A46 Newark Bypass

Scheme Number: TR010065

Statement of Common Ground with Think Again A46 Winthorpe Action Group

February 2025

Figure 2.4 Locations of Temporary Works Areas Required During Construction

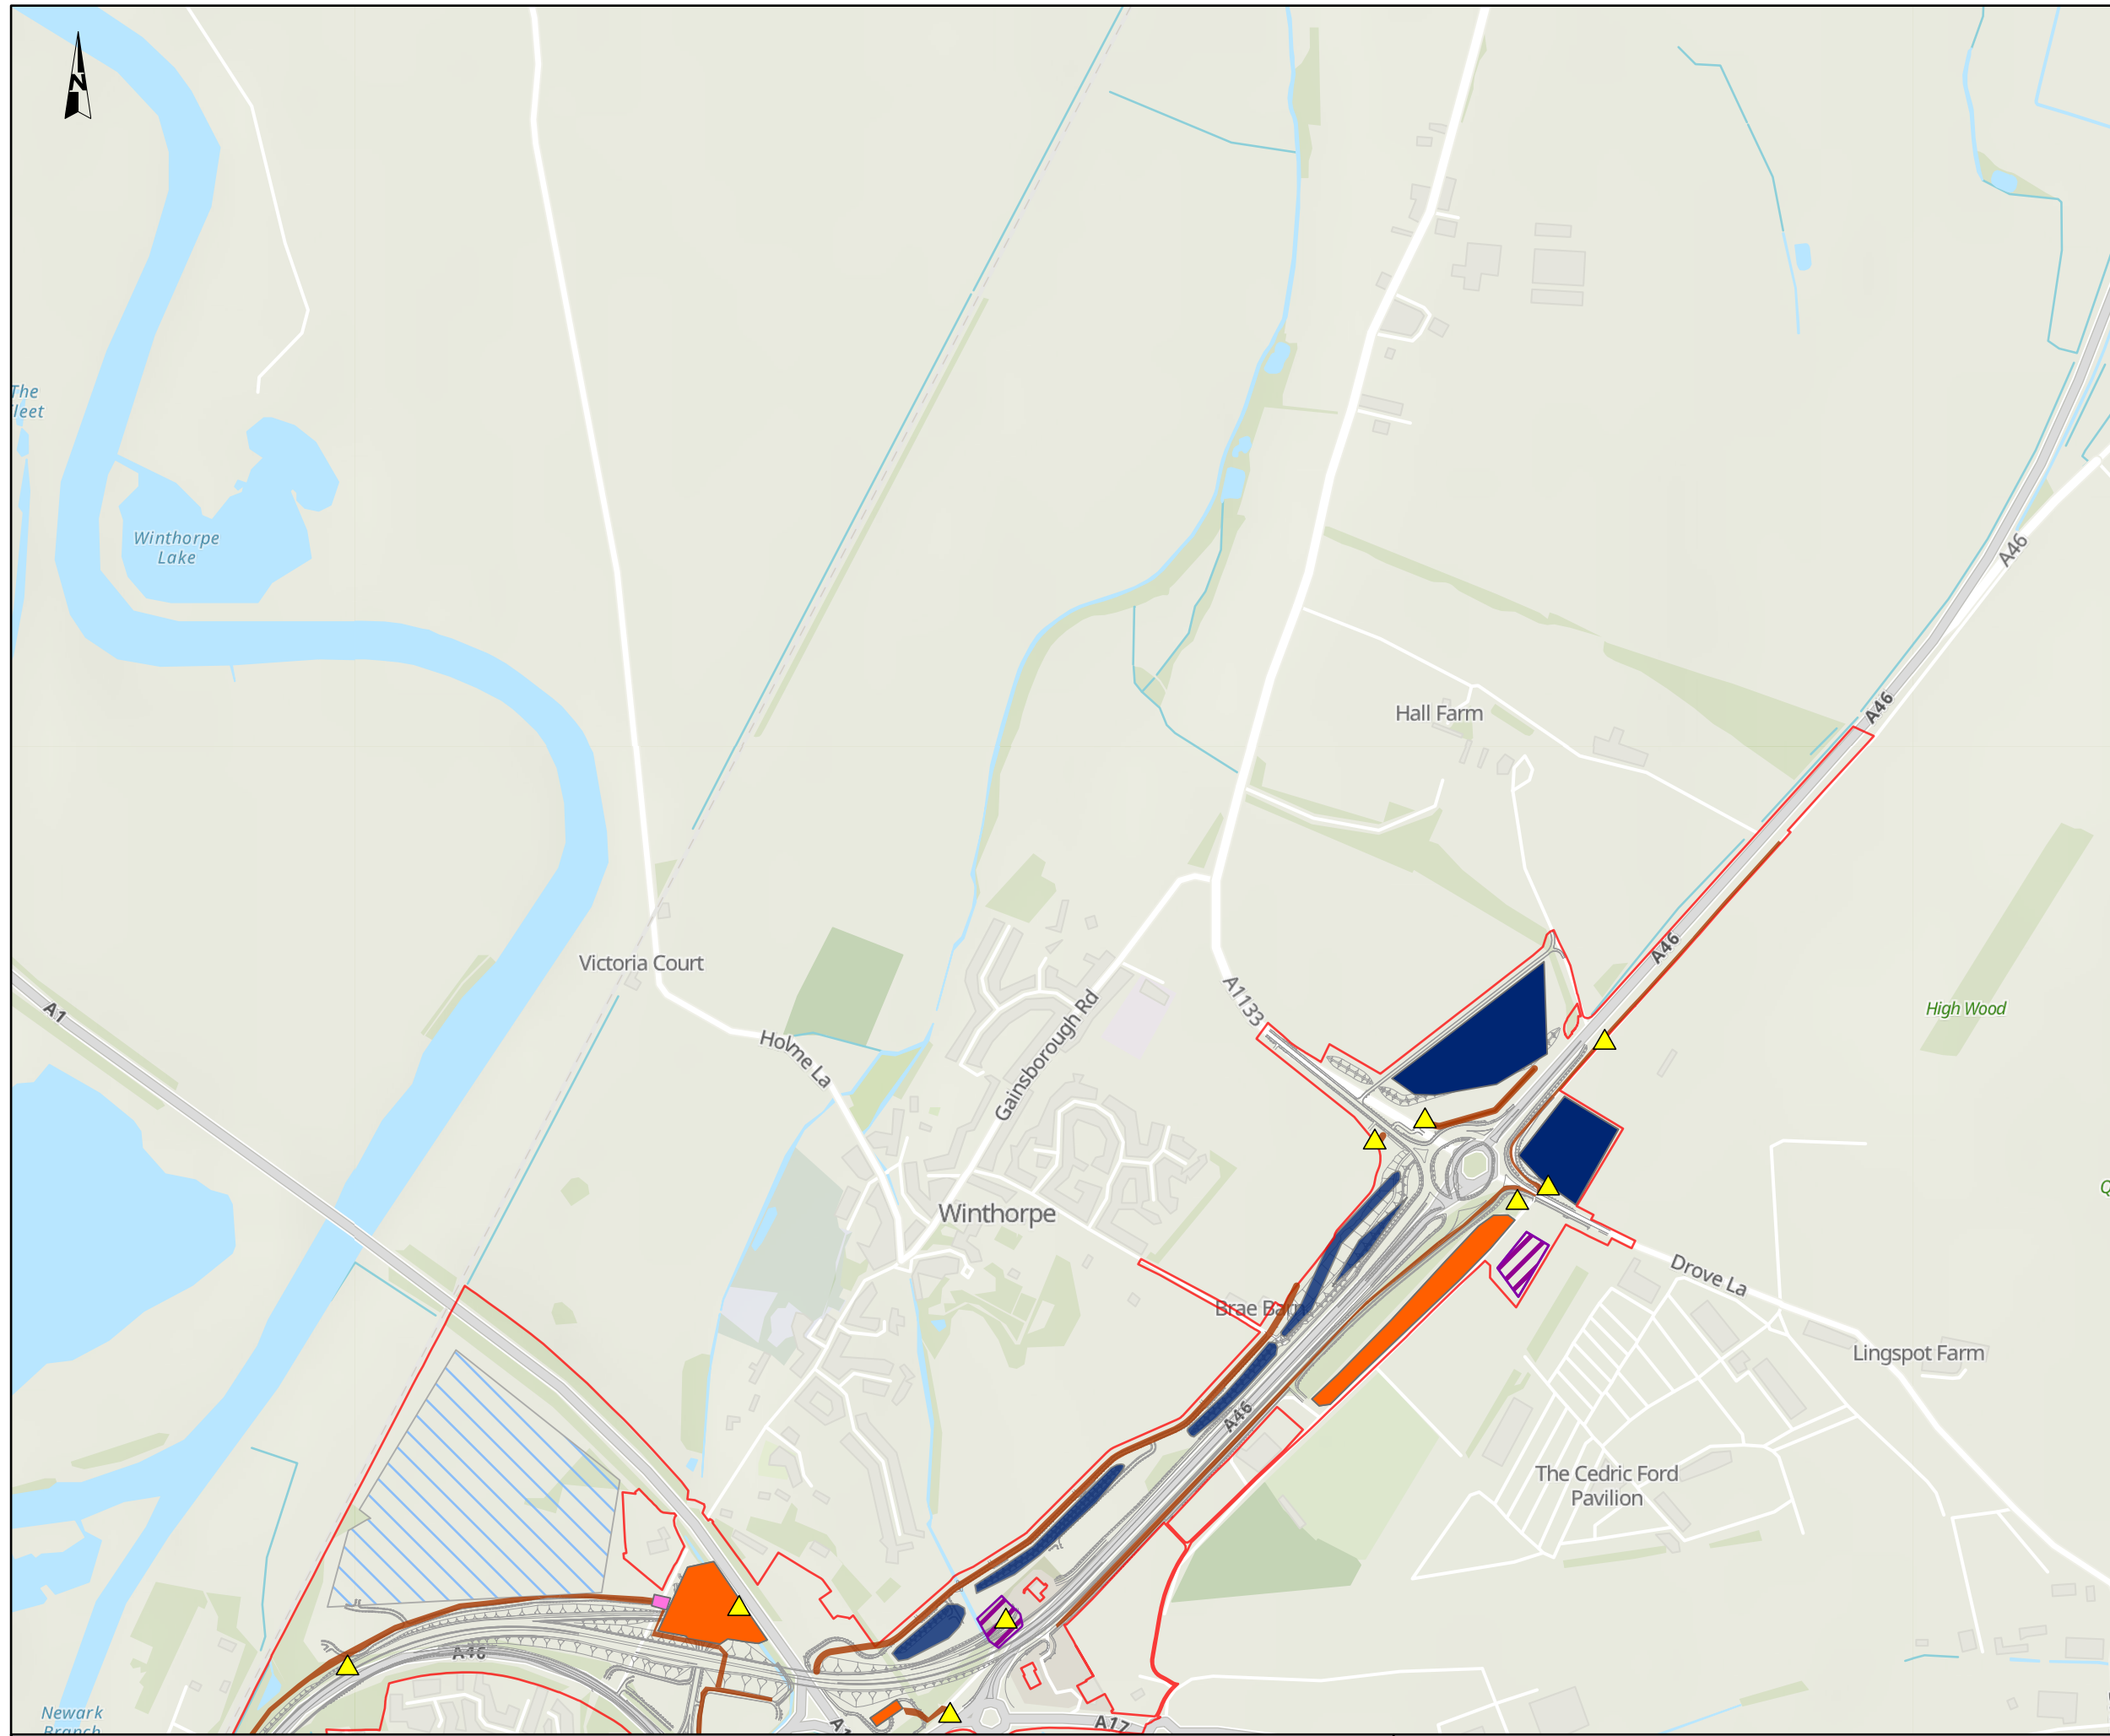
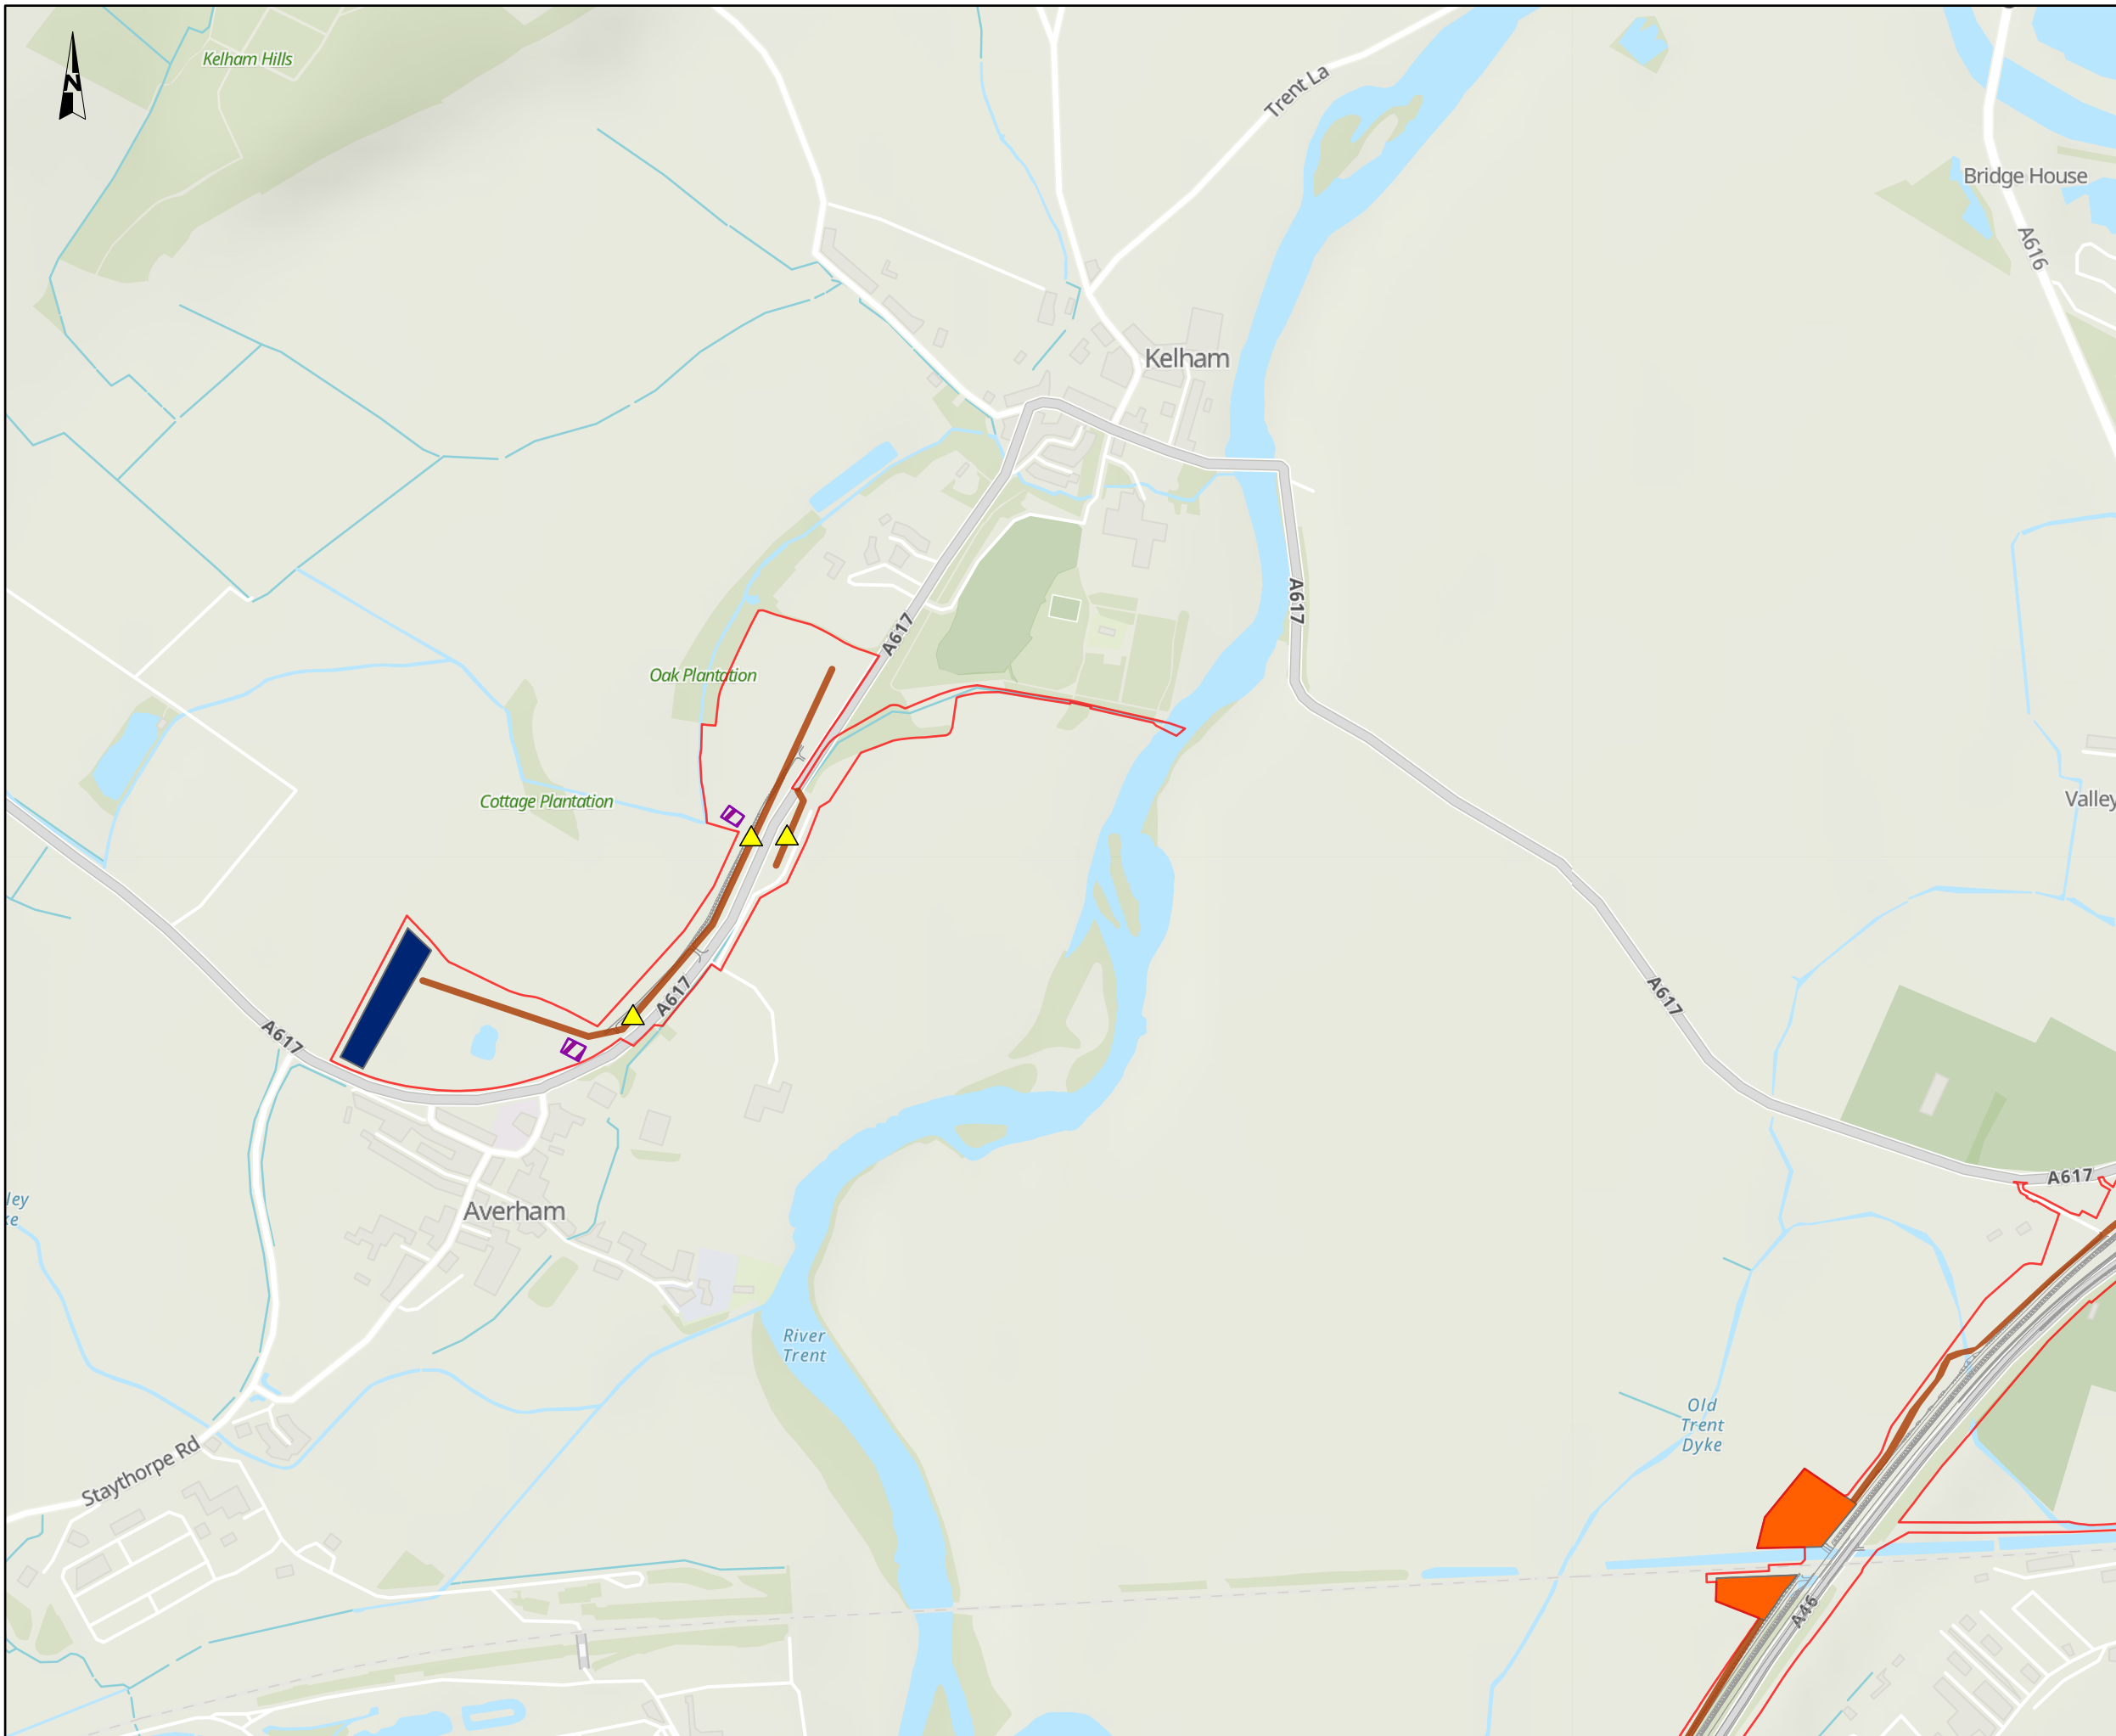
20.	Construction Compounds	Figure 2.4 Locations of Temporary Works Areas Required During Construction of the Environmental Statement Figures [AS-027] Table 2-6 in Chapter 2 The Scheme of the Environmental Statement [APP-046]	What construction compounds and works access facilities will be located in the Winthorpe area?	The location of the construction compounds and works access areas within the Winthorpe area are detailed on Figure 2.4 Locations of Temporary Works Areas Required During Construction of the Environmental Statement Figures [AS-027] and in Table 2-6 in Chapter 2 The Scheme of the Environmental Statement [APP-046].	Agreed	24/09/2024
